EAST FORK JIMMY CAMP CREEK CHANNEL DESIGN CREEKSIDE DEVELOPMENT

Kiowa Project No. 18020
MAY 1, 2019

LORSON RANCH
CREEKSIDE DEVELOPMENT
EAST FORK JIMMY CAMP CREEK
CHANNEL PLAN AND PROFILE STA 10+00 TO STA 22+00
EL PASO COUNTY, COLORADO

LORSON RANCH
CREEKSIDE DEVELOPMENT
EAST FORK JIMMY CAMP CREEK
 CHANNEL PLAN AND PROFILE STA 35+00 TO STA 45+00
 EL PASO COUNTY, COLORADO

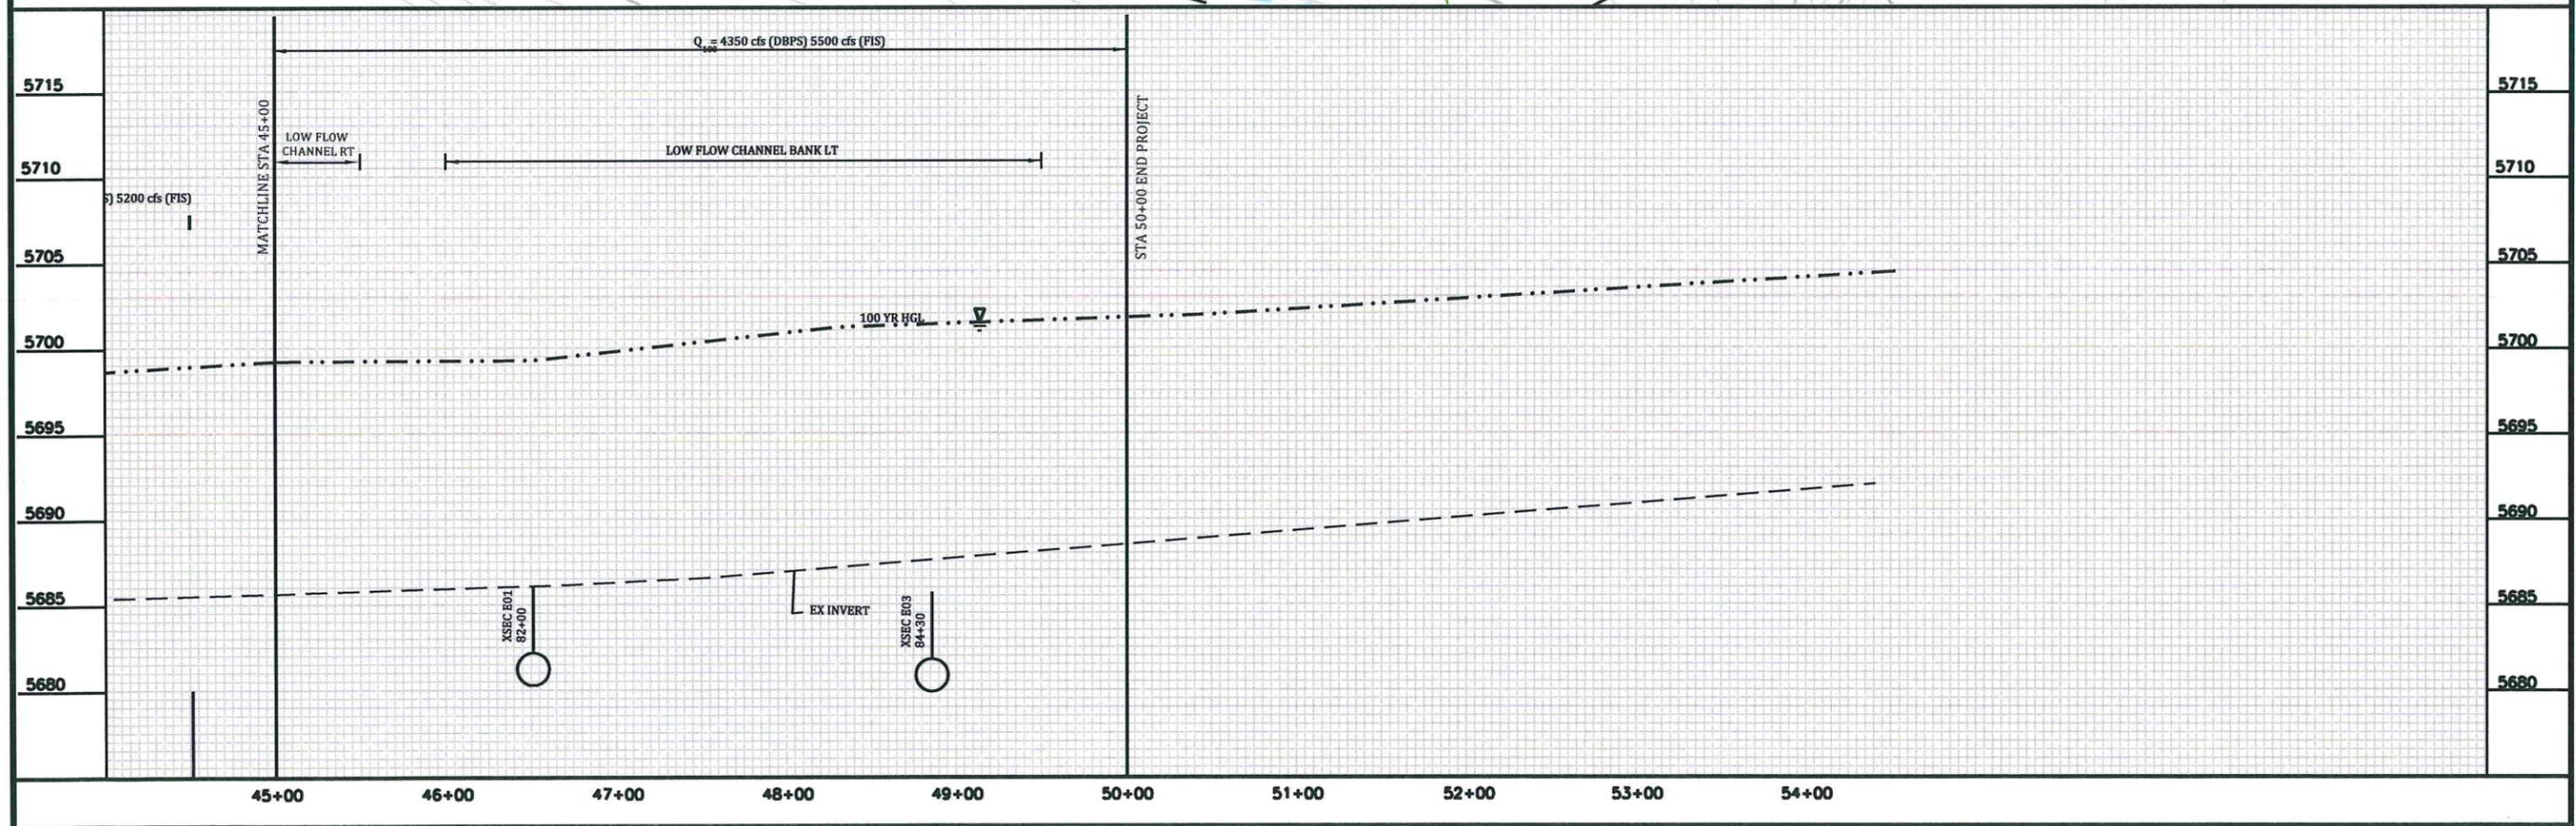
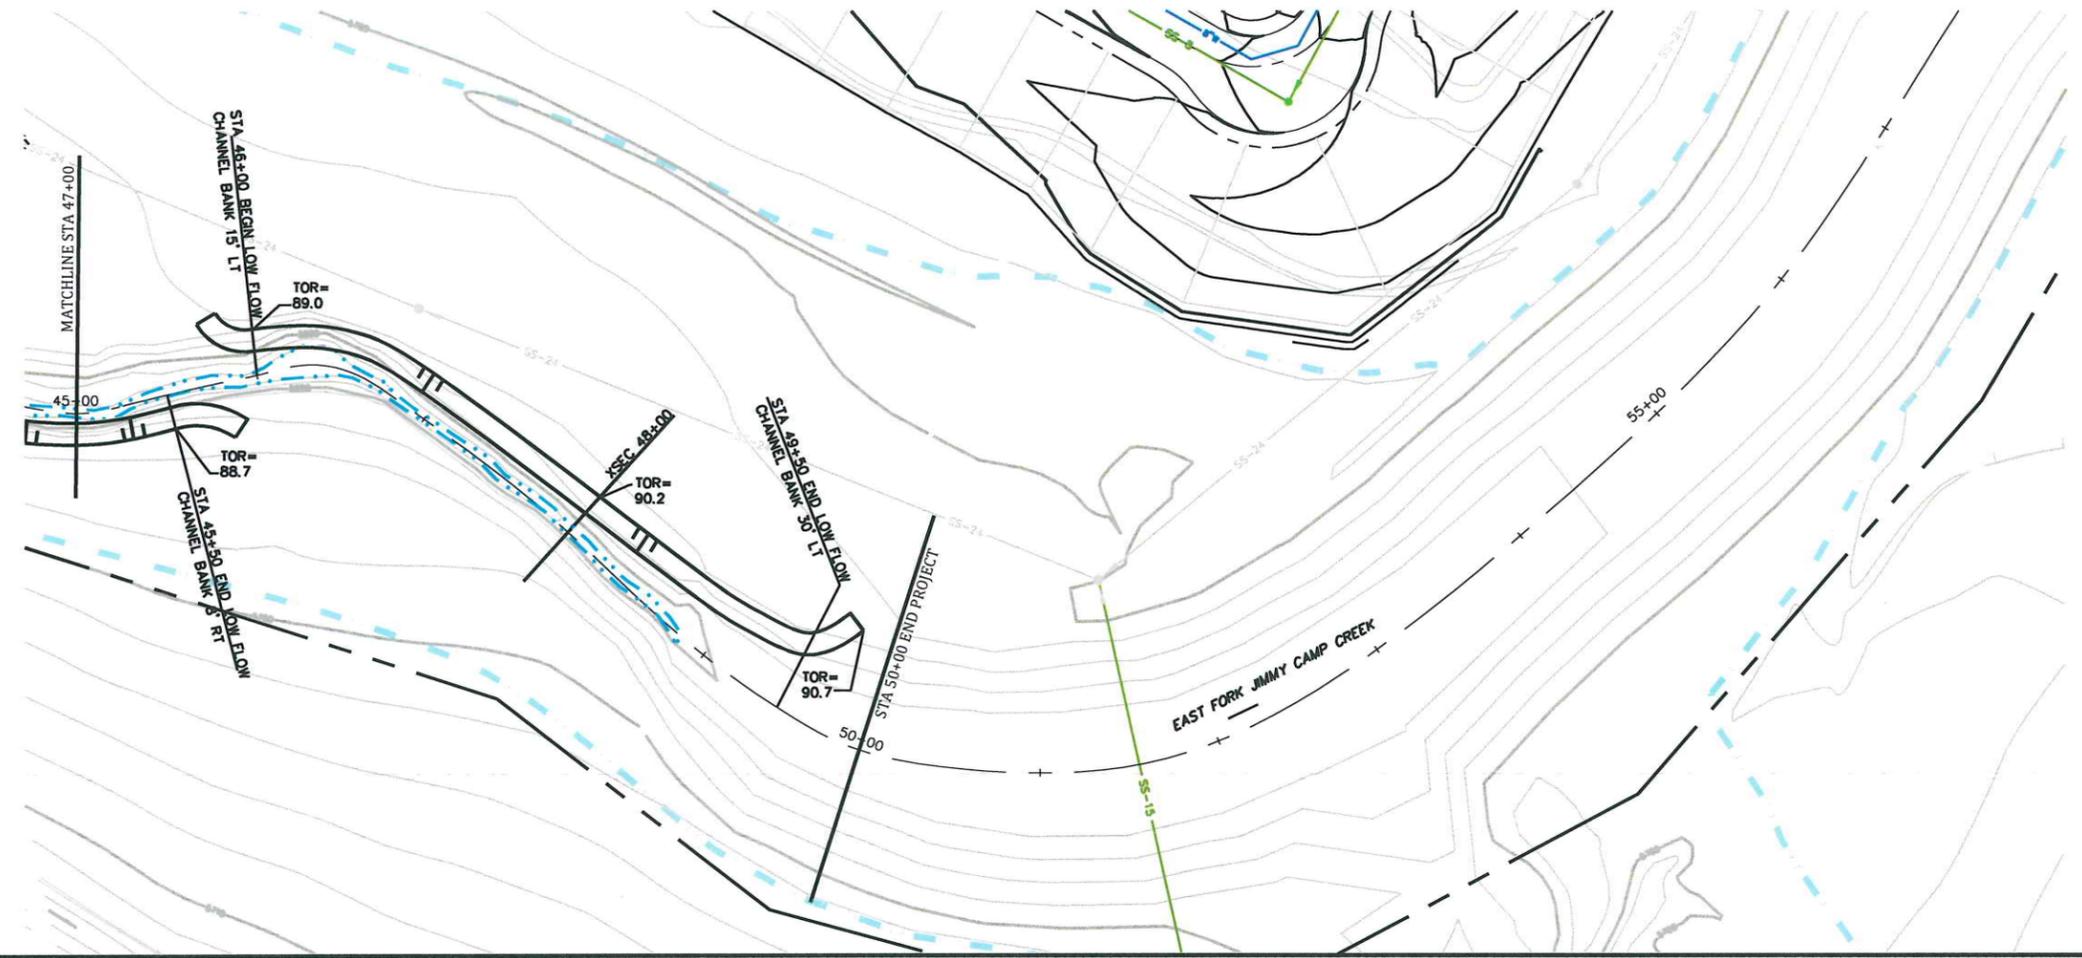
Provide details on half-section low-flow channel.

**LORSON RANCH
CREEKSIDE DEVELOPMENT
EAST FORK JIMMY CAMP CREEK
CHANNEL PLAN AND PROFILE
EL PASO COUNTY, COLORADO**

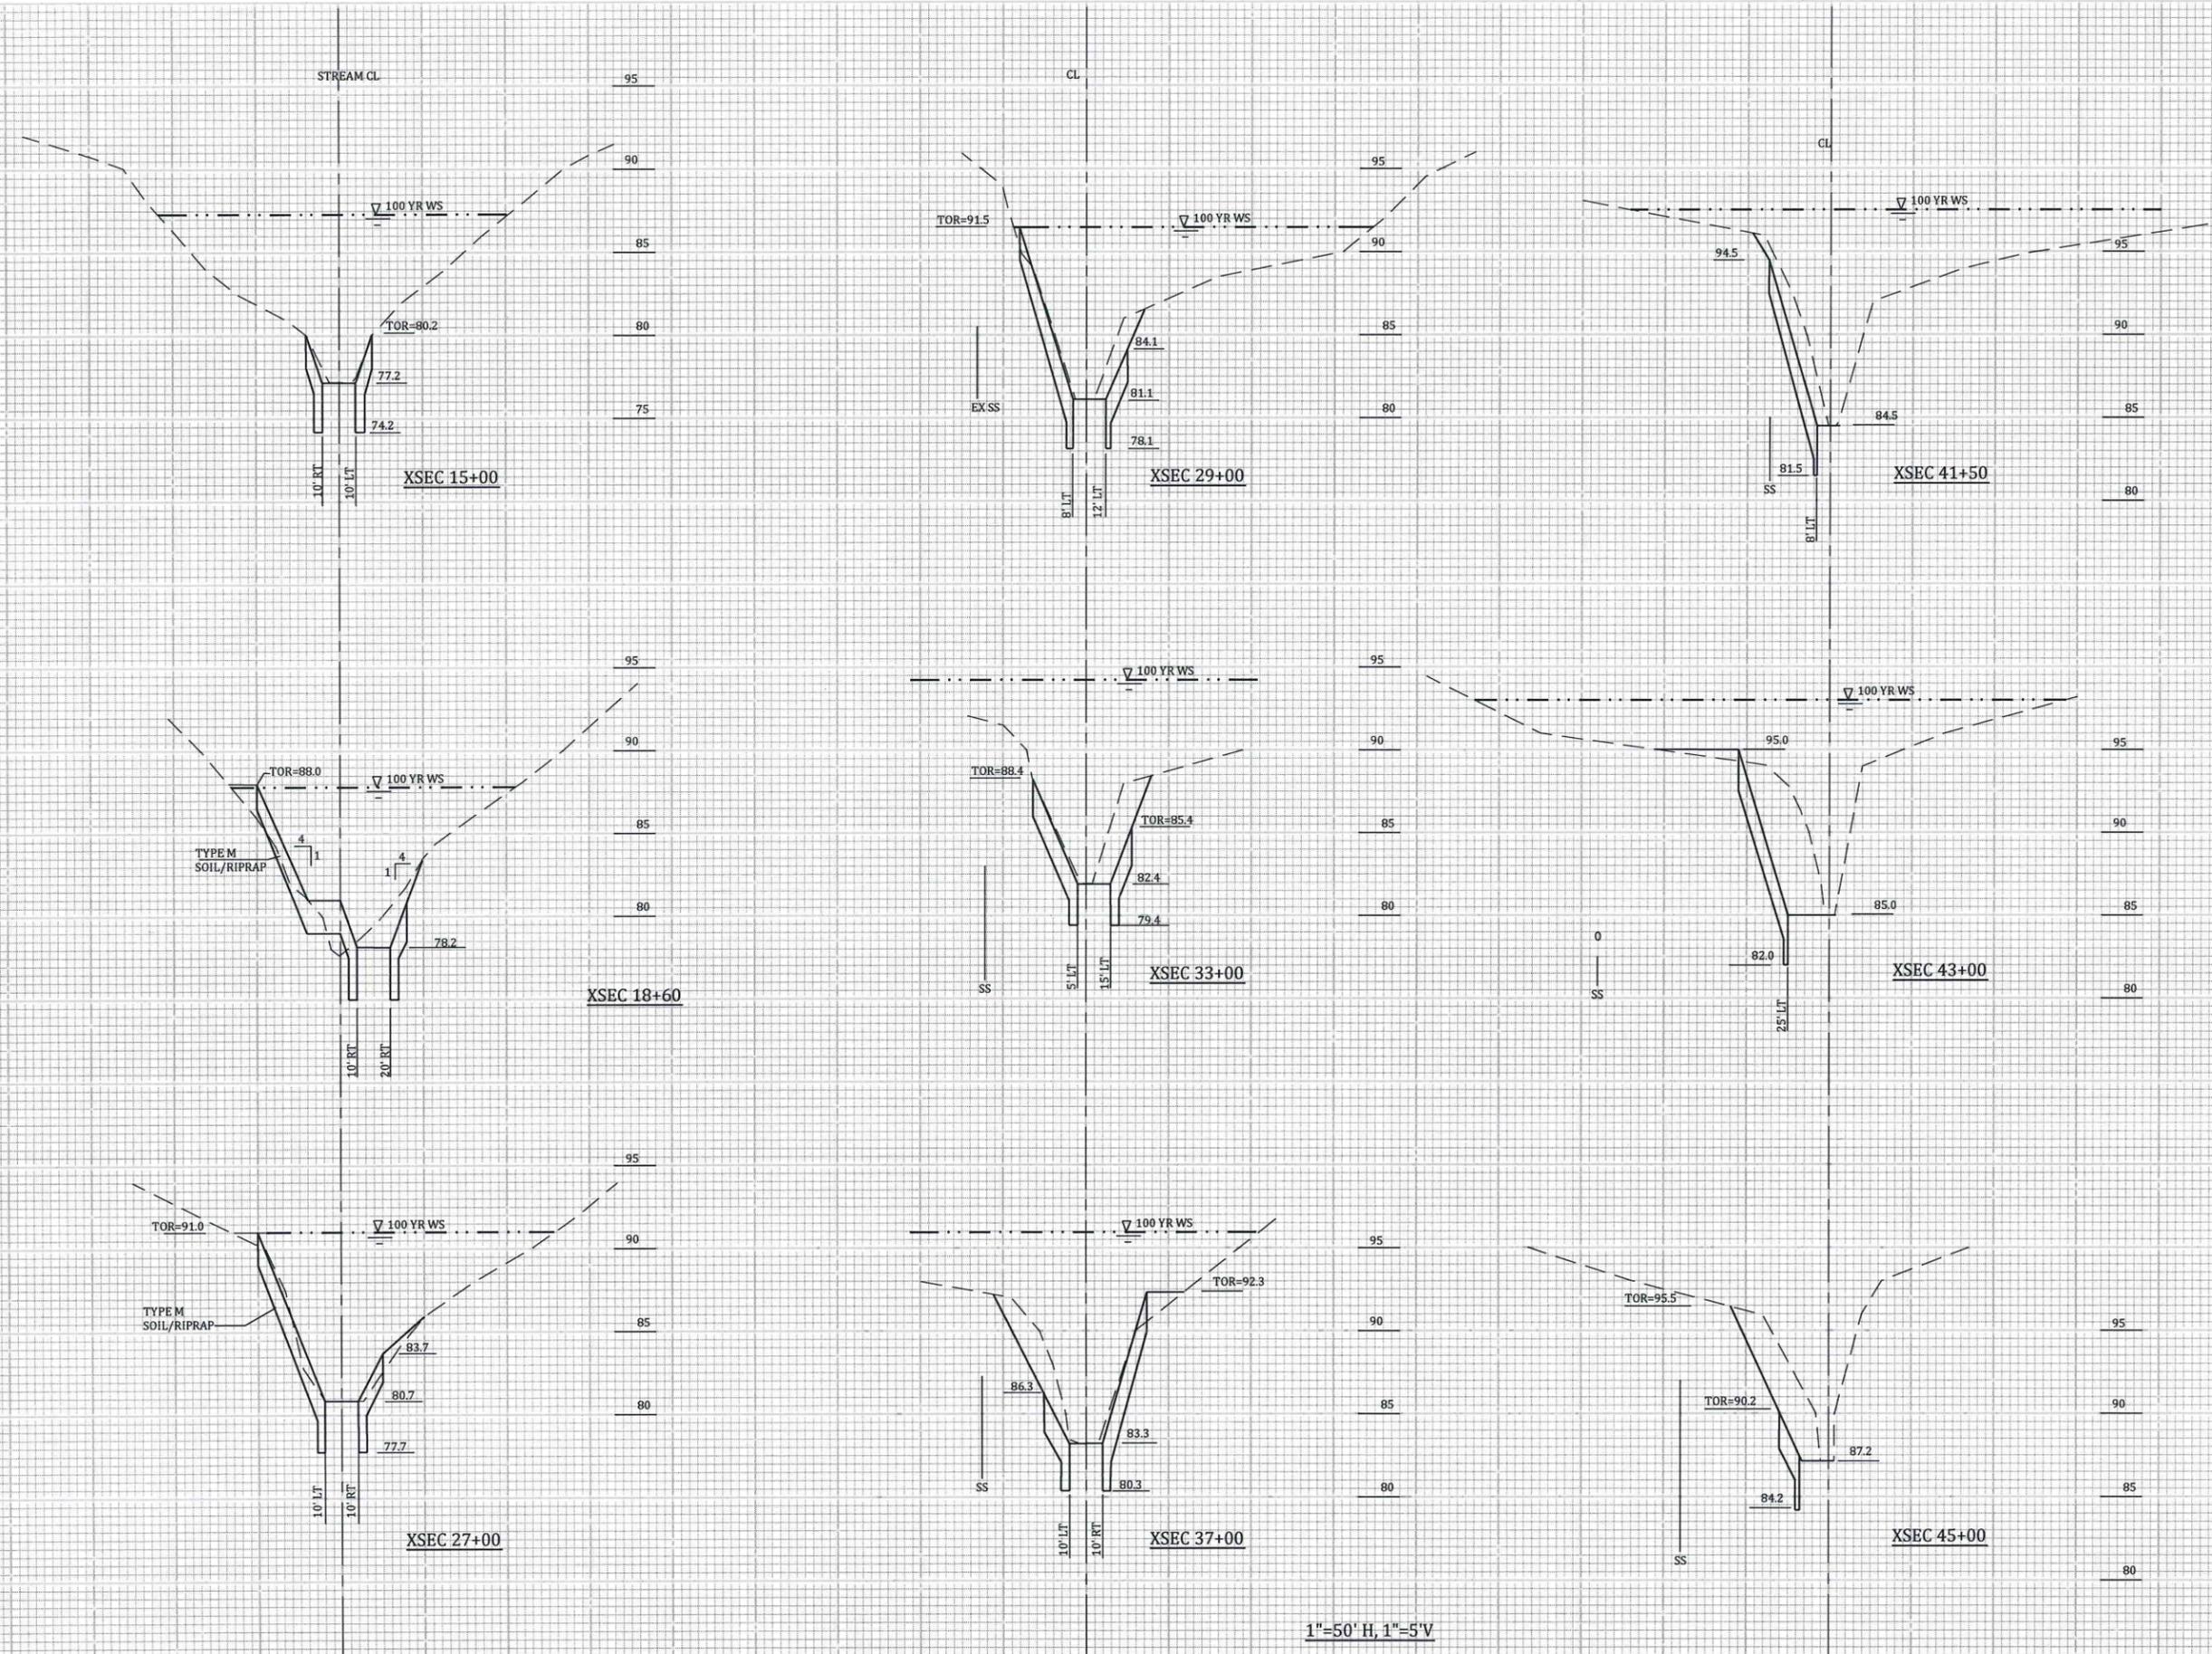
Specify sizes on the plan or provide a table with stationing.

Is this used anywhere?

How does this work when it's shown on only one side on the plan?
